Our ref: SE1612-ISS-XX-XX-CO-C-0002

RE: Pound Place – Drainage Submission for 64Bed Scheme.

Please find attached our revised submission to discharge Condition 3 of the planning application for the above noted site.

I write in response to your comments dated 30/06/20 listing 12 points to reconcile and below is our response in order of your list:

DRAWING TITLE:
PROPOSED DRAINAGE LAYOUT
64 BED
SHEET 1

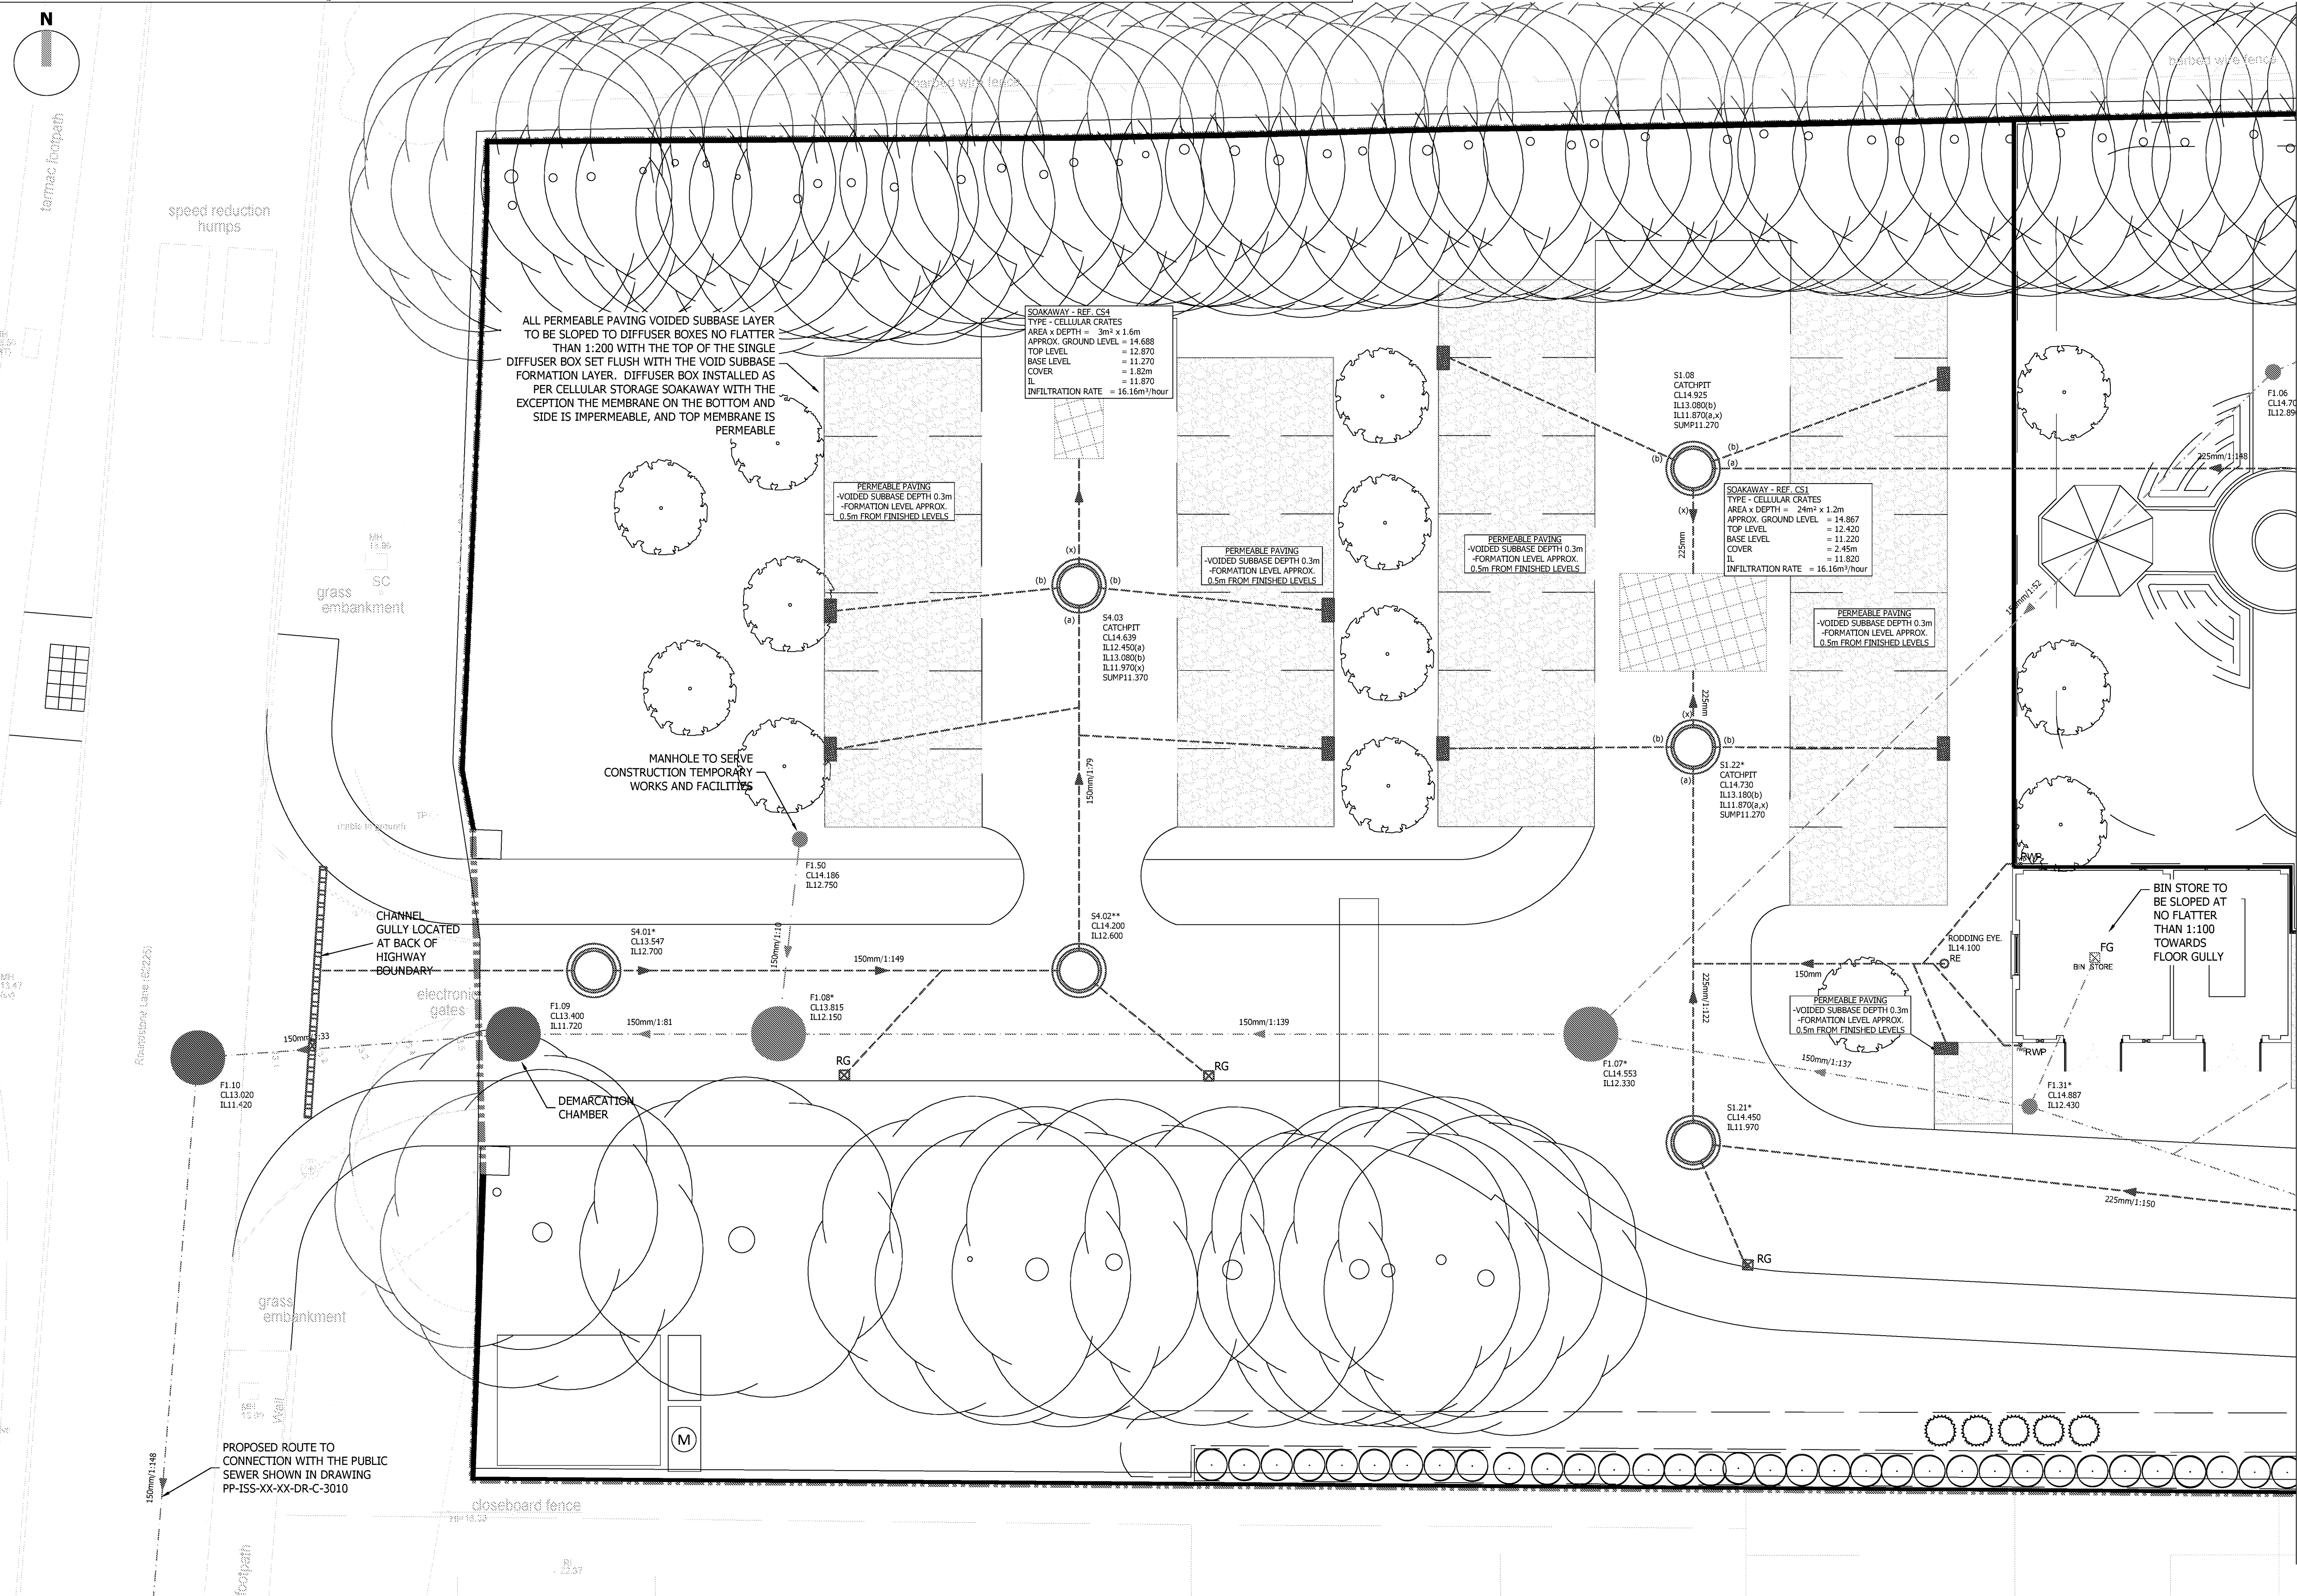
1. Ground and formation levels have been added for all permeable paving areas (dwg PP-ISS-XX-XX-DR-C-3011 to PP-ISS-XX-XX-DR-C-3013)
2. Revised catchment plan provided (dwg PP-ISS-XX-XX-DR-C-3500 to PP-ISS-XX-XX-DR-C-3501)

3. Porosity amended and revised results provided (calculations SE1612-ISS-XX-XX-CA-C-0051 to SE1612-ISS-XX-XX-CA-C-0054)
4. Invert levels added to diffuser boxes (dwg PP-ISS-XX-XX-DR-C-3011 to PP-ISS-XX-XX-DR-C-3013)

5. Gully cover levels added (dwg PP-ISS-XX-XX-DR-C-3011 to PP-ISS-XX-XX-DR-C-3013)
6. The whole site and finished floor level have been raised which is the likely result in discrepancies comparing various documents & revisions. Attached are the latest drainage plans (dwg PP-ISS-XX-XX-DR-C-3011 to PP-ISS-XX-XX-DR-C-3013), manhole schedules (dwg PP-ISS-XX-XX-DR-C-3100 to PP-ISS-XX-XX-DR-C-3101) and model outputs (calculations SE1612-ISS-XX-XX-CA-C-0051 to SE1612-ISS-XX-XX-CA-C-0054) for the 64 bed scheme to the previously approved 62bed scheme. Please note as the floor plans has changed and increased, manholes have been relocated, added or removed resulting in the references being amended.
